From:
Sent: 12 February 2026 16:12
To: DC Admin
Subject: 2025/91770 - objection
Attachments: Planning objection letter 260210.docx

I object to the planning application. I have read the public objection (id 1117331 / 9/12/25) and whole heartedly agree with its contents. In addition, I would like to add the following:

project no.	drawing no.	revision
2391	02

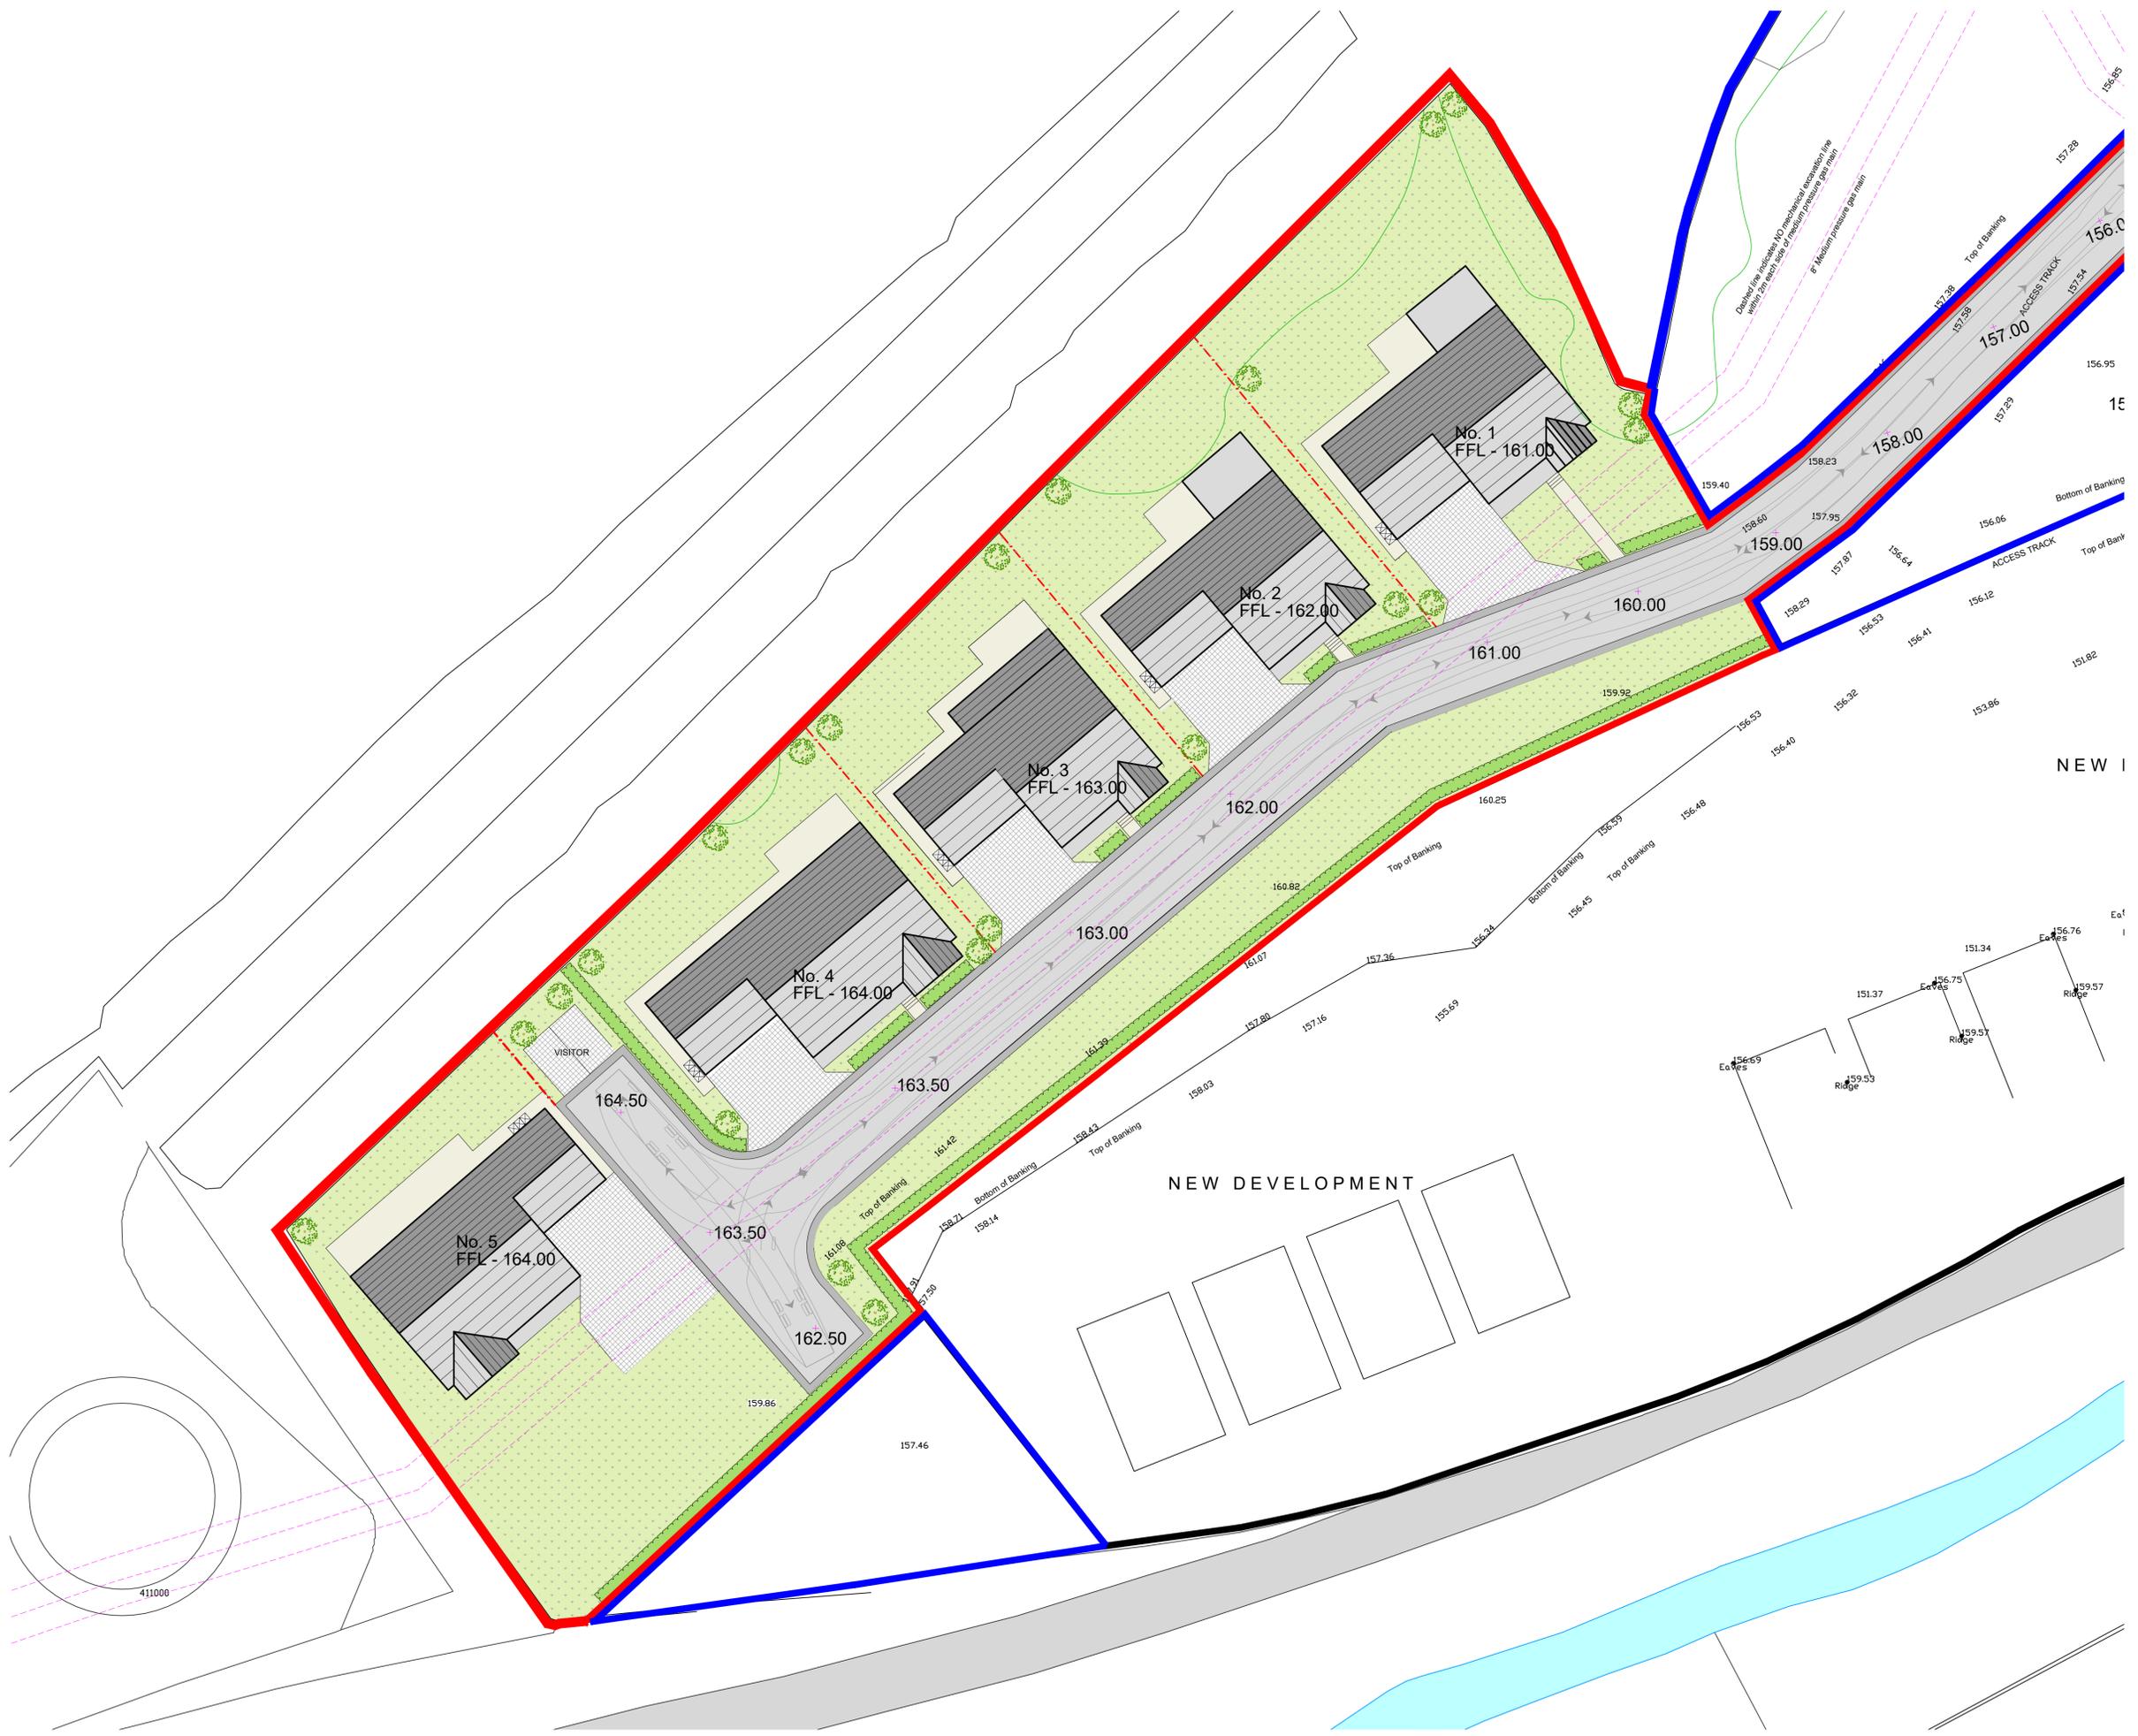
1. Ownership of the land is unclear. The application states (page 12) that the applicant is not the sole owner of all the land to which the application relates and that the applicant cannot (and therefore presumably has not) given notice to all other owners. The only attempt to identify land owners appears to have been a single notice in the Examiner in June 2025. This is inadequate.

2. Access to Station Road. The highways authority are “pleased to see” that the red line boundary now extends to the adopted highway (Huddersfield Road) but this cannot be right given the application is on the basis that the applicant does not own (all of) the relevant land. The access to Station Road is not passable for two cars side-by-side, which is dangerous, given Huddersfield Road has a 40mph limit. Adding five homes of the proposed size will add between 10 – 15 additional vehicles as standard, plus all service and delivery vehicles which increases the danger beyond an acceptable level. I am very surprised that the highways authority have approved the access despite their previous clear and proper concern.
